Our ref: HA/2015/117562/01-L01
Your ref: LU/248/15/PL
Date: 02 November 2015

**CHANGE OF USE FROM OFFICE (CLASS A2) TO A DWELLING
3 ARCADE ROAD LITTLEHAMPTON BN17 5AP**

Environment Agency position

Proposed Ground Floor Plan

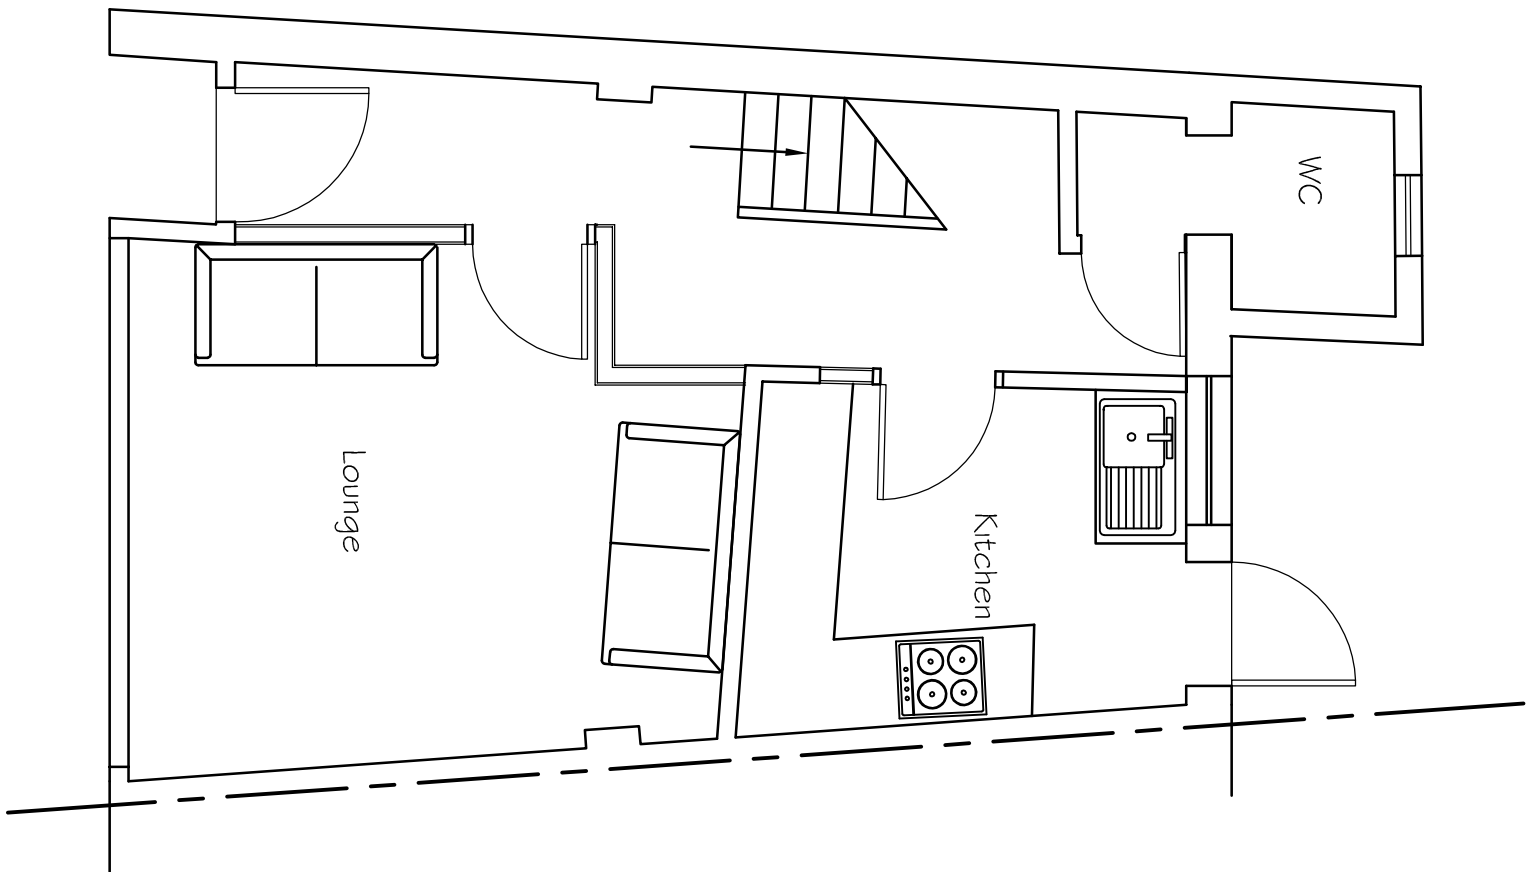
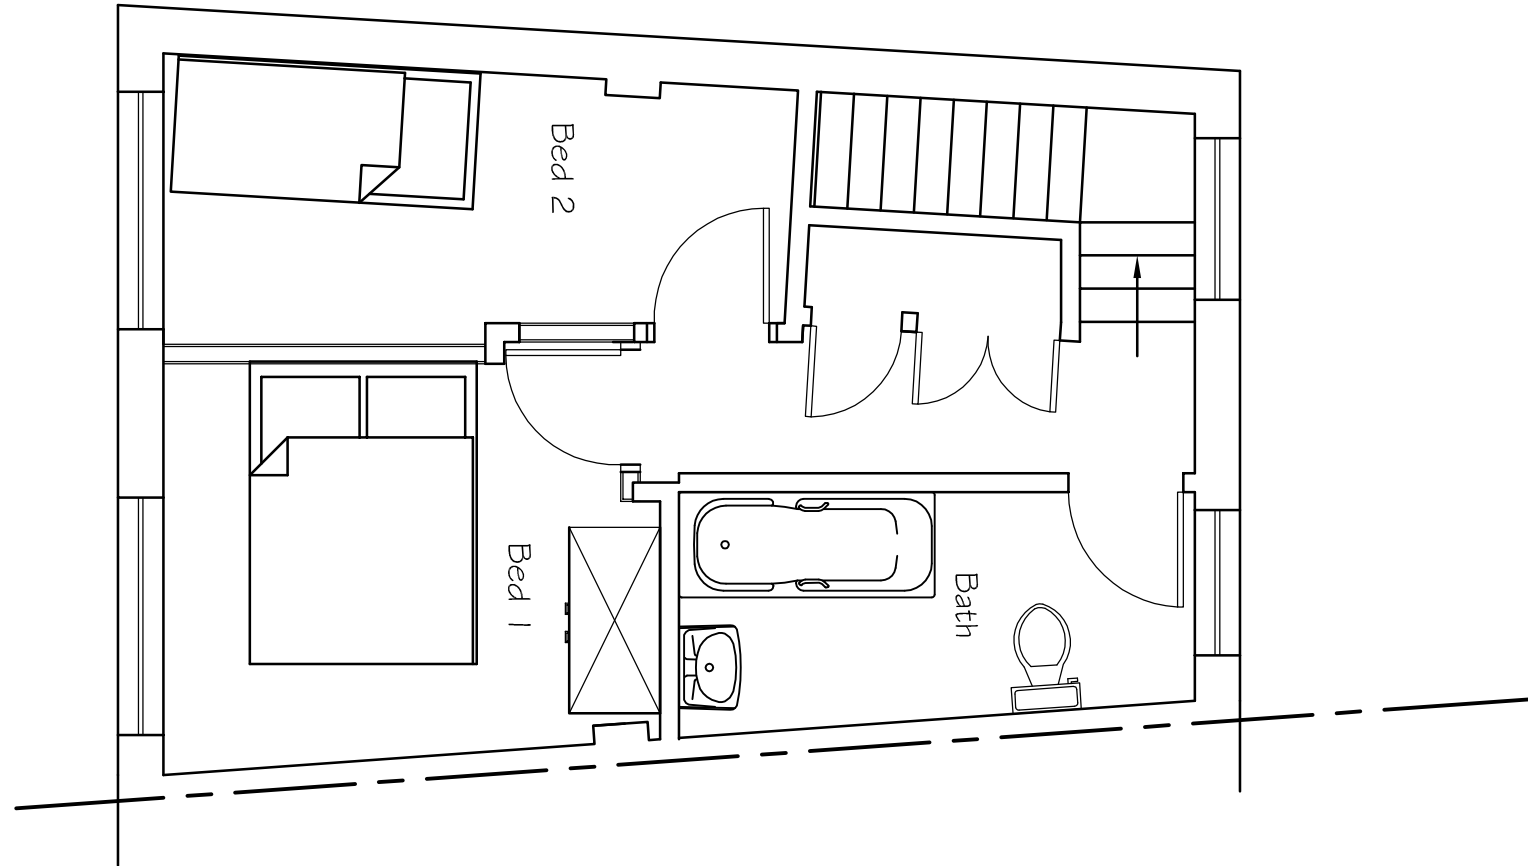
1. *Consider how people will be kept safe from flood hazards identified*
2. *Consider the effect of a range of flooding events including extreme events on people and property.*
3. *Consider the requirement for flood emergency planning including flood warning and evacuation of people for a range of flooding events up to and including the extreme event.*
4. *All finished floor levels for living accommodation should be 600mm above the 1 in 200 climate change flood event level.*
